From: Sue Howell
Sent: 17 July 2018 16:47
To: Planning.Responses
Cc: David Easton
Subject: RE: Planning Consultation on: AL/44/18/RES

Comments from Greenspace

NOTIFICATION FROM ARUN DISTRICT COUNCIL
The Town & Country Planning Act 1990 (as amended)
Town & country Planning (Development Management Procedure)
(England) Order 2015 - Article 6
Approval of Reserved Matters Following Outline Approval
APPLICATION AL/44/18/RES
NO:

Registered: 11th April 2018
Site Address: Oldlands Farm Steyning Way Bersted PO22 9NW
Grid Reference: 494384 101415
Description of Works: Application for all reserved matters following outline consent AL/58/15/OUT (Hybrid Application) for up to 20,453 sqm of B2 general industrial floorspace together with B8 warehousing & distribution floorspace (as amended by subsequent Variation of Conditions 11, 12 & 37).

Drawing Title:  
**Planting Plan (Sheet 1 of 4)**

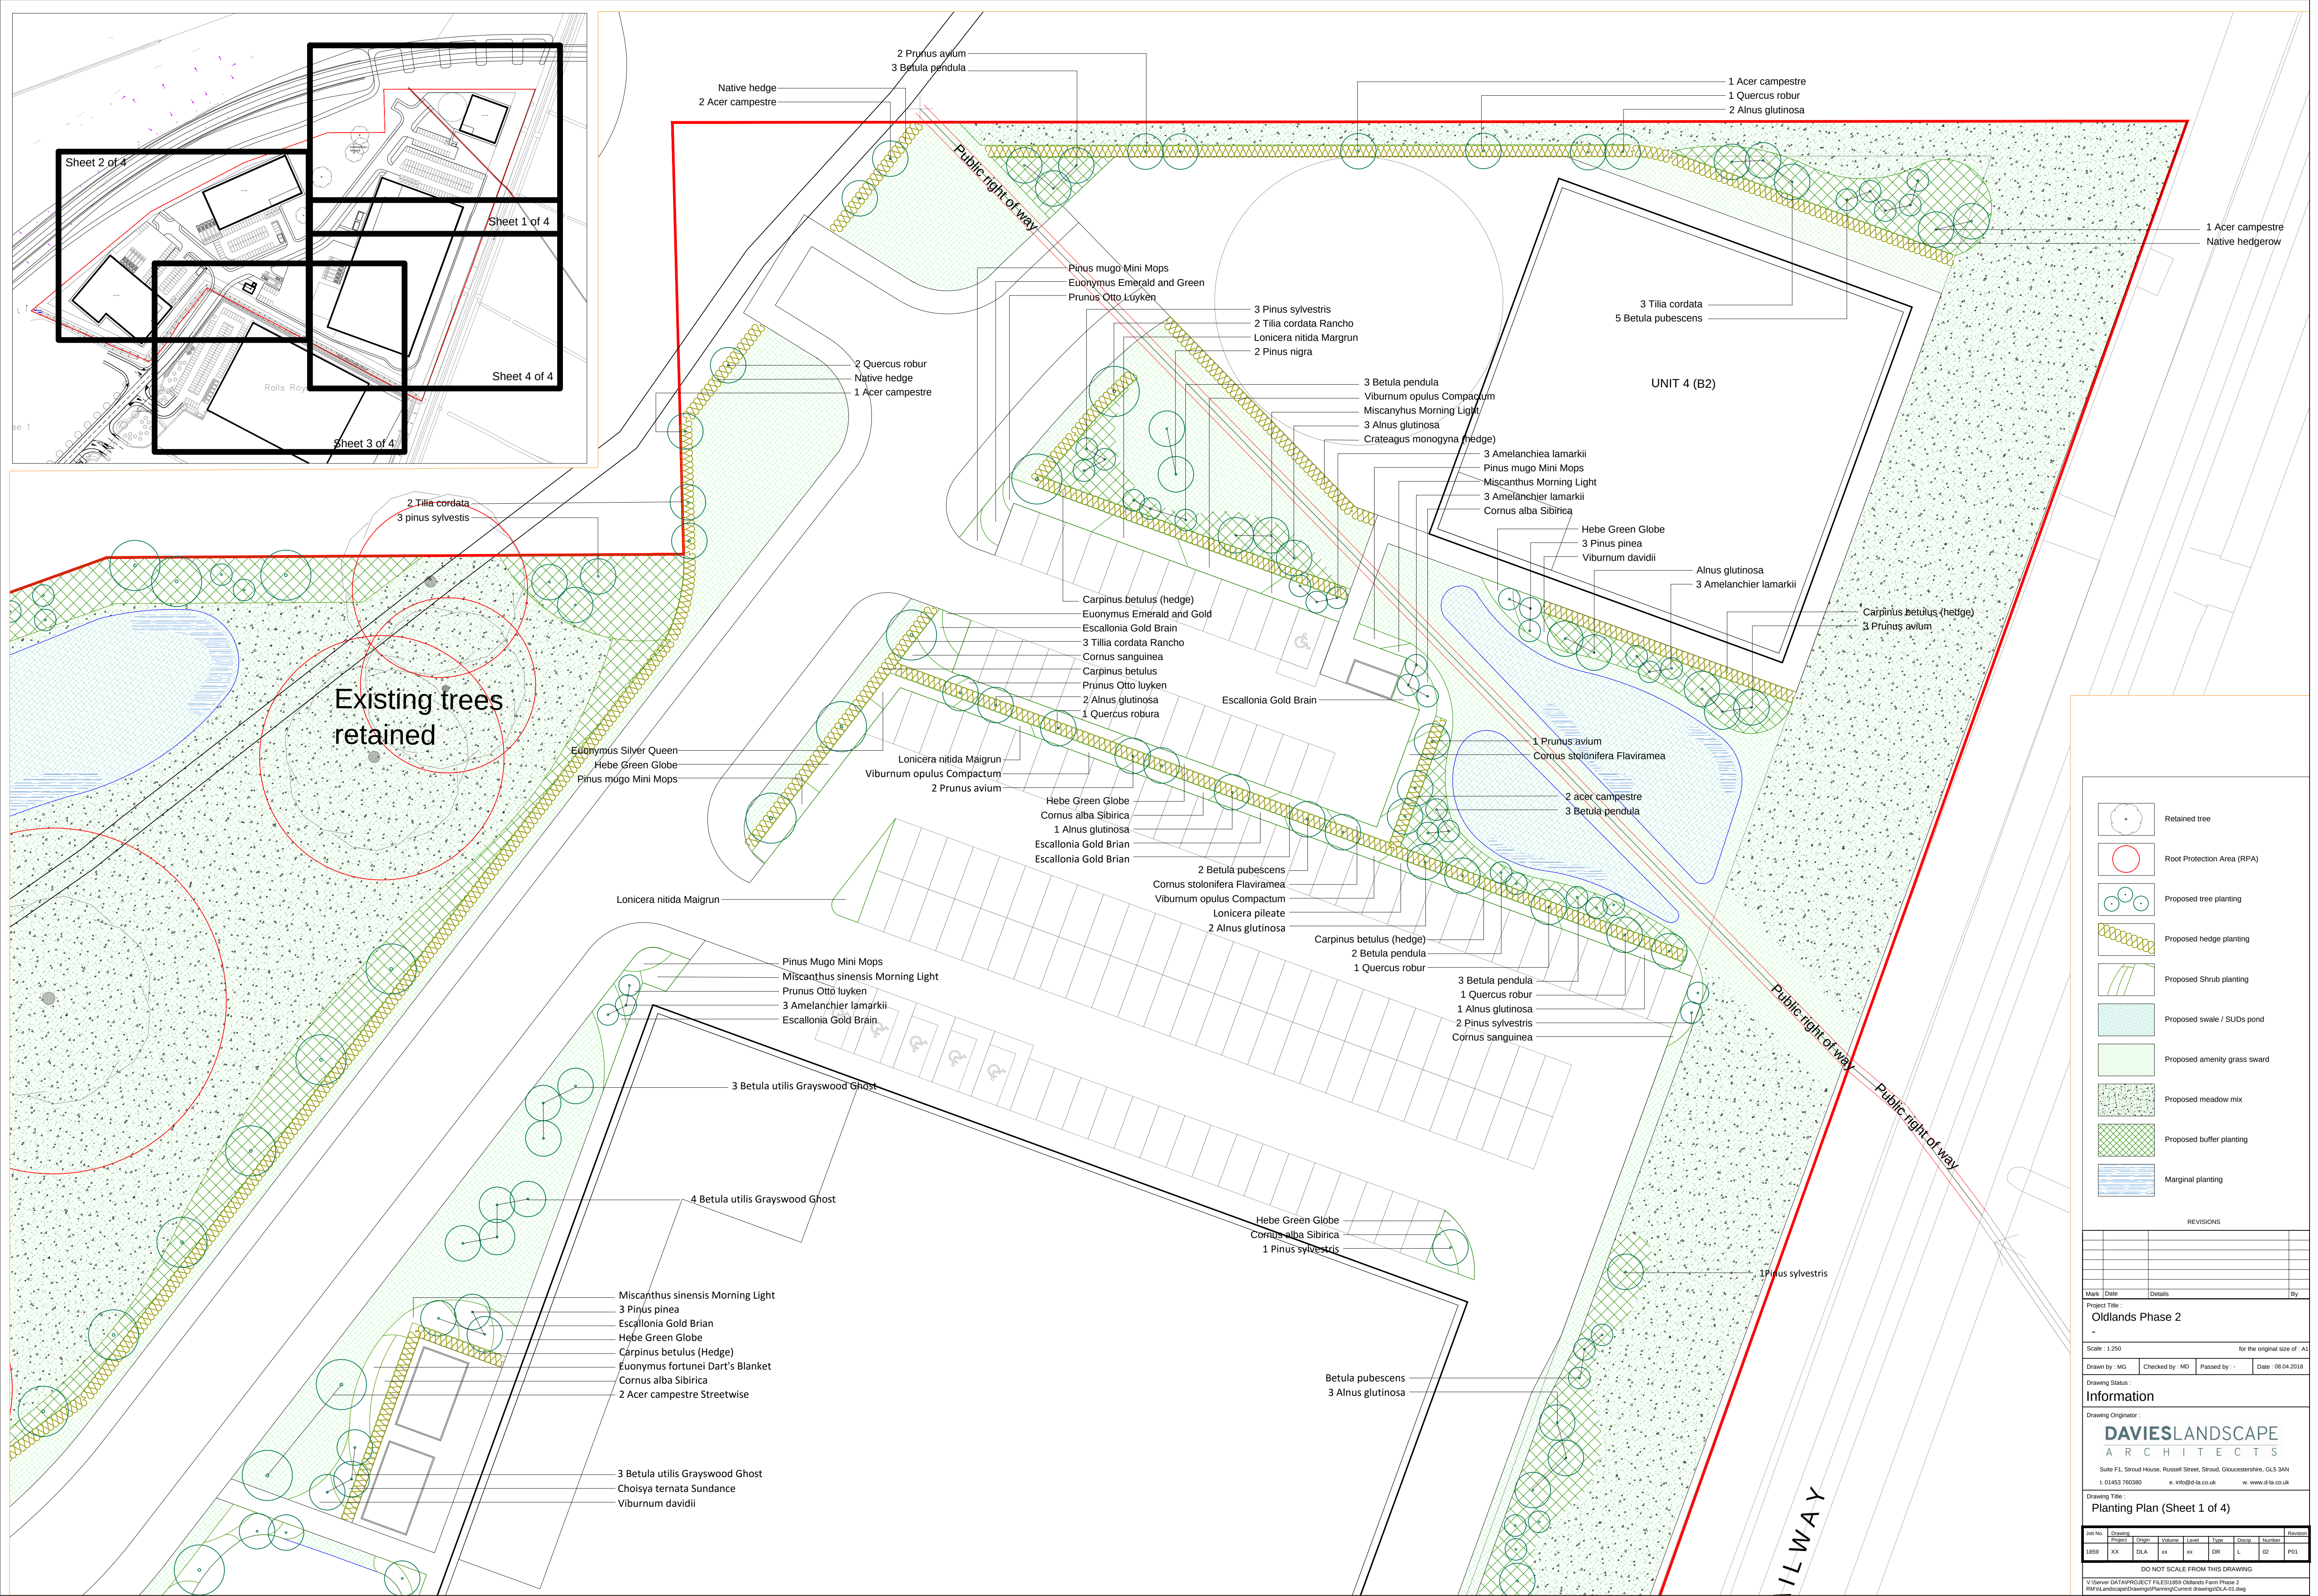
Indicative planting has been illustrated within the plans DLA.1859-X-X-X-X-DR-L-01 P02 Illustrative Masterplan and further detail given within Planting Plans (Sheets 1-4) plan dwg 1859 xx DLA xx xx DR L 02/03/04/05 Rev P01. The reserved matter re landscaping was for the submission of a full landscape scheme to be submitted for approval, detailing species choice, position, densities and size at time of planting. This is required in plan and list form and in relation to the trees and vegetation to be retained so that a clear picture of the proposals can be seen. These details are required to ensure that appropriate screening is provided, maintaining and uncompromising the setting and ensuring that the proposals fit within the area of neighbouring development. We note that the information contained within these drawings and within the Detailed Planting Scheme and Management Plan document is insufficient in the detail above and whilst provides a scheme which is fitting for location in species choice further detailing as above still needs to be provided.

The Oak trees along the north/eastern boundary edge identified for retention, must be protected during the works as they have been identified to provide good visual amenity in addition to their biodiversity importance. These trees have the potential for a long life expectancy, with potential to become a prominent feature within the landscape and are worthy of protection, with adequate

fencing according to the BS5837 (2012) Provision for fencing according to each of the trees' calculated root protection area must be erected prior to the commencement development activities.

The reserved matters conditioned as 9 and 31 under application AL/58/15/OUT **have not been met under this application AL/44/18/RES** and therefore my recommendation is that the Landscaping detailing information is still required to be submitted for approval.

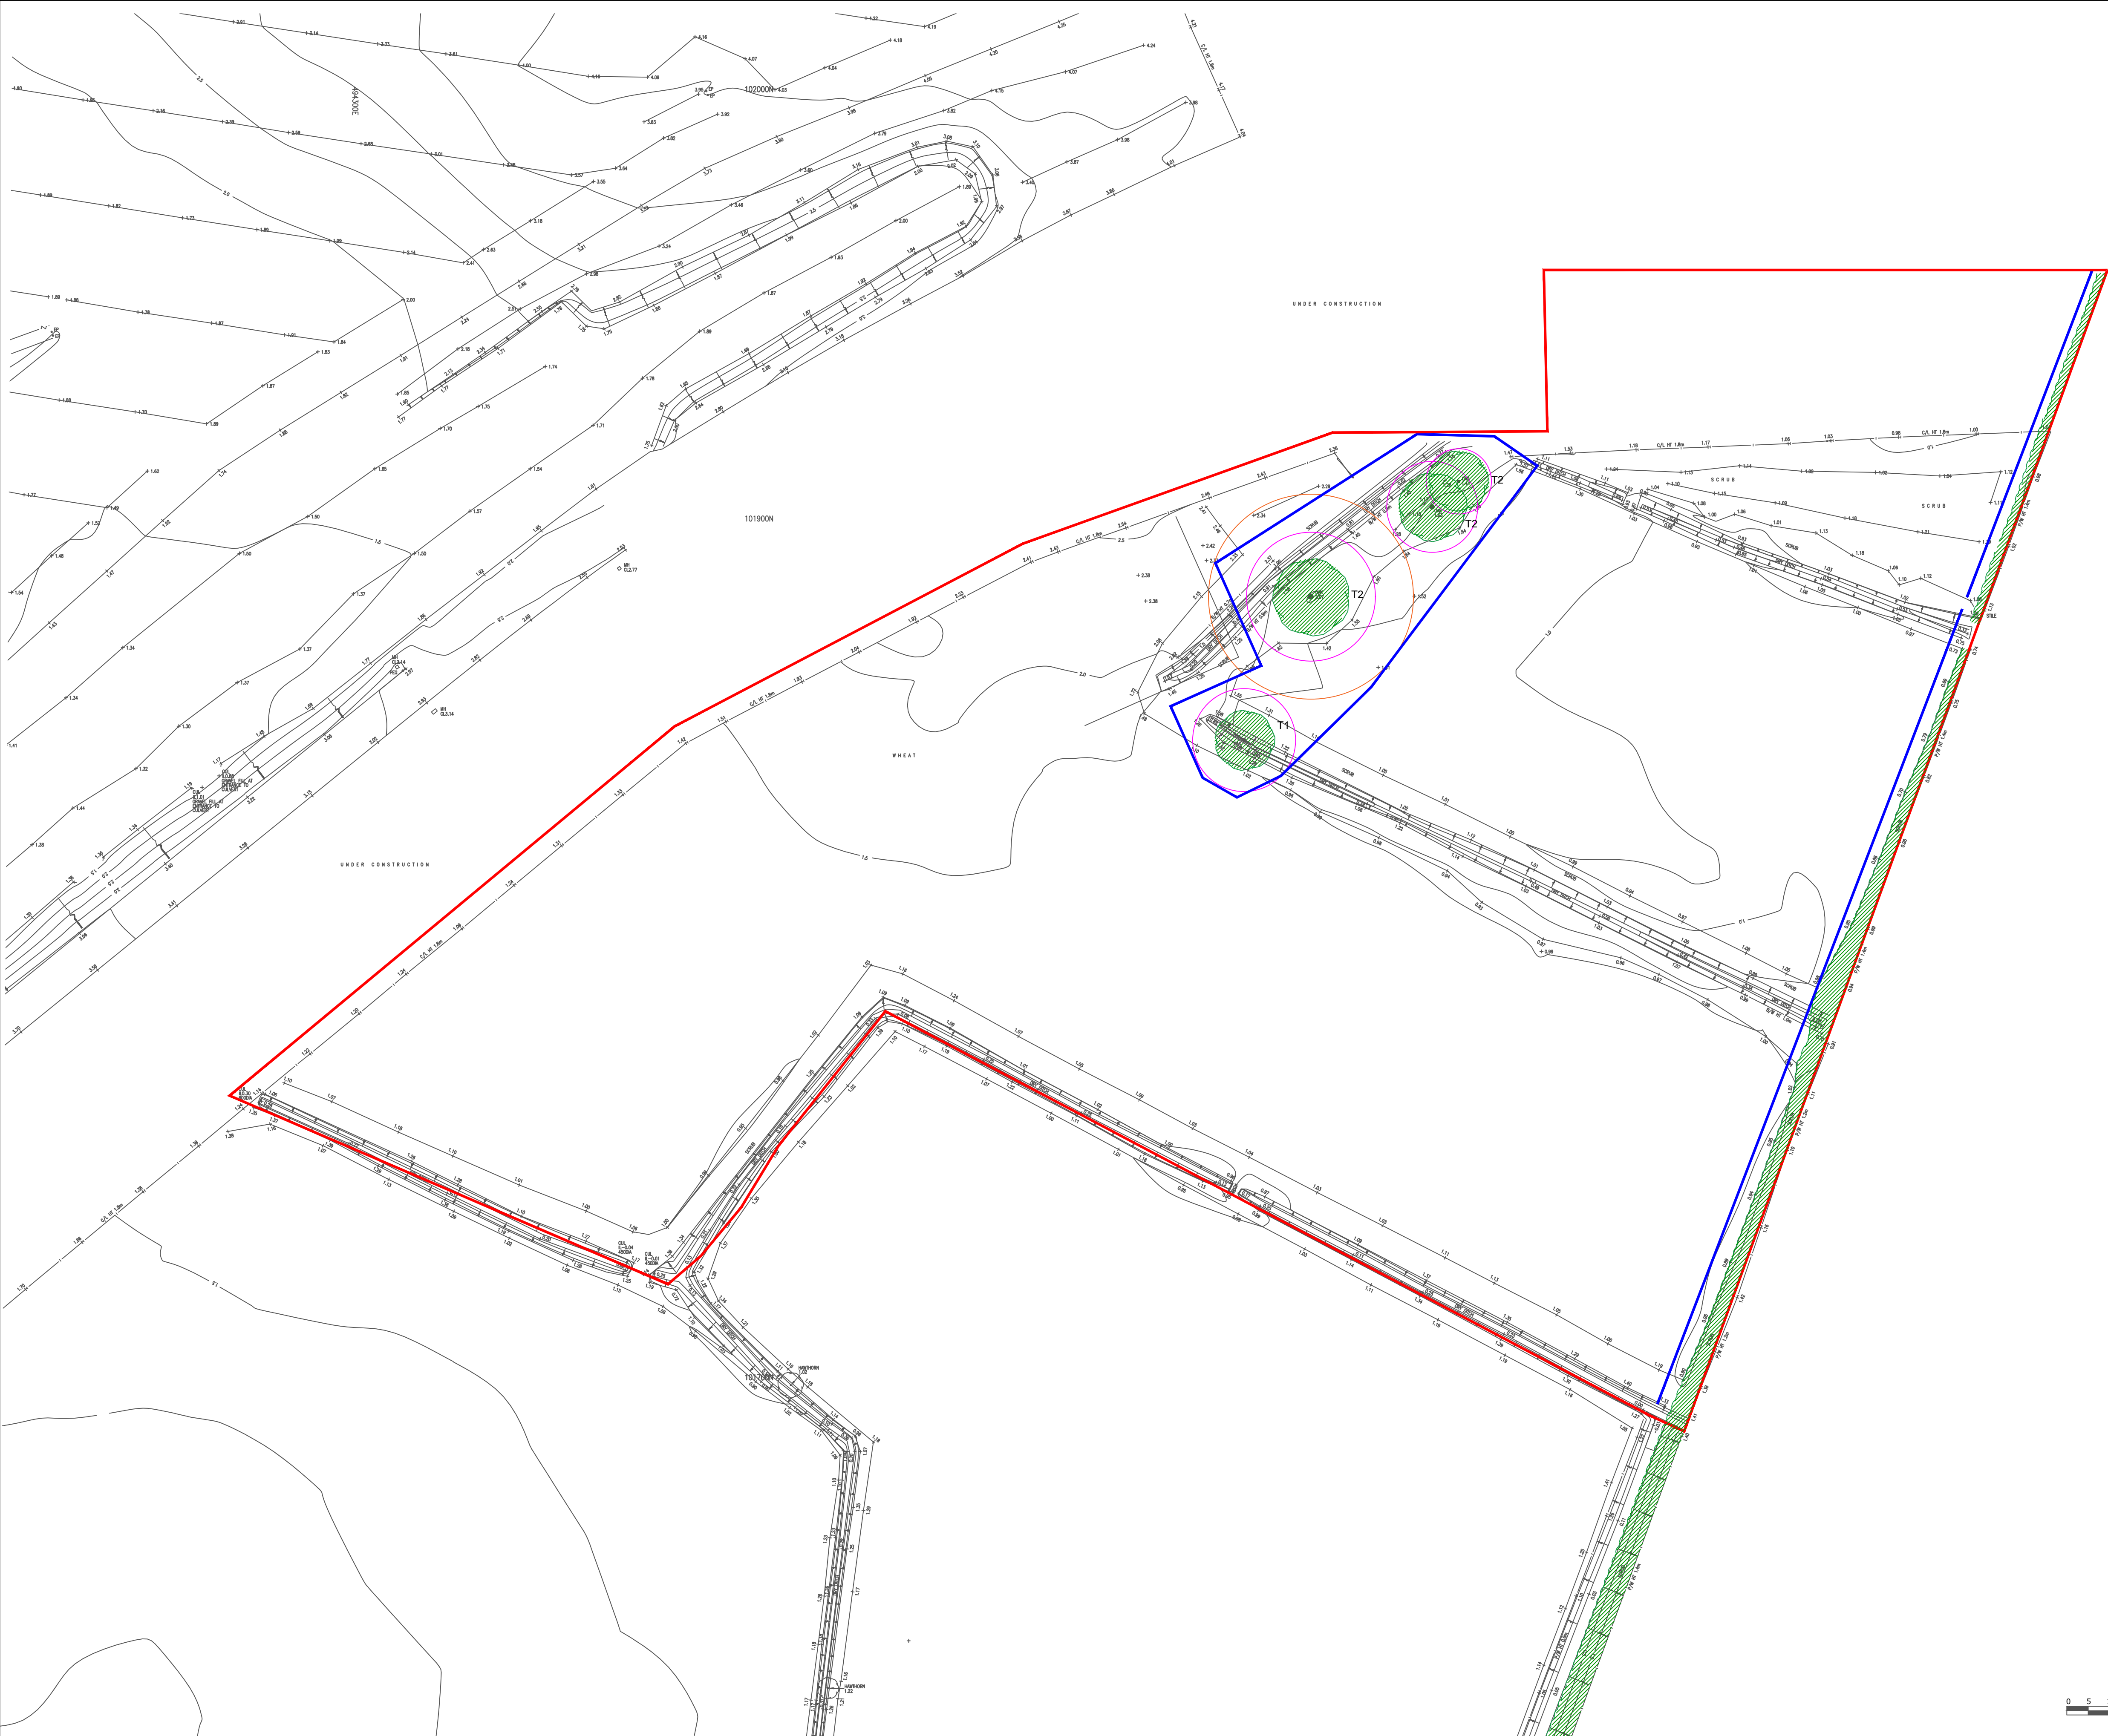
A tree survey relating to existing trees has been undertaken. The tree protection fencing identified with the tree protection plan conditioned.
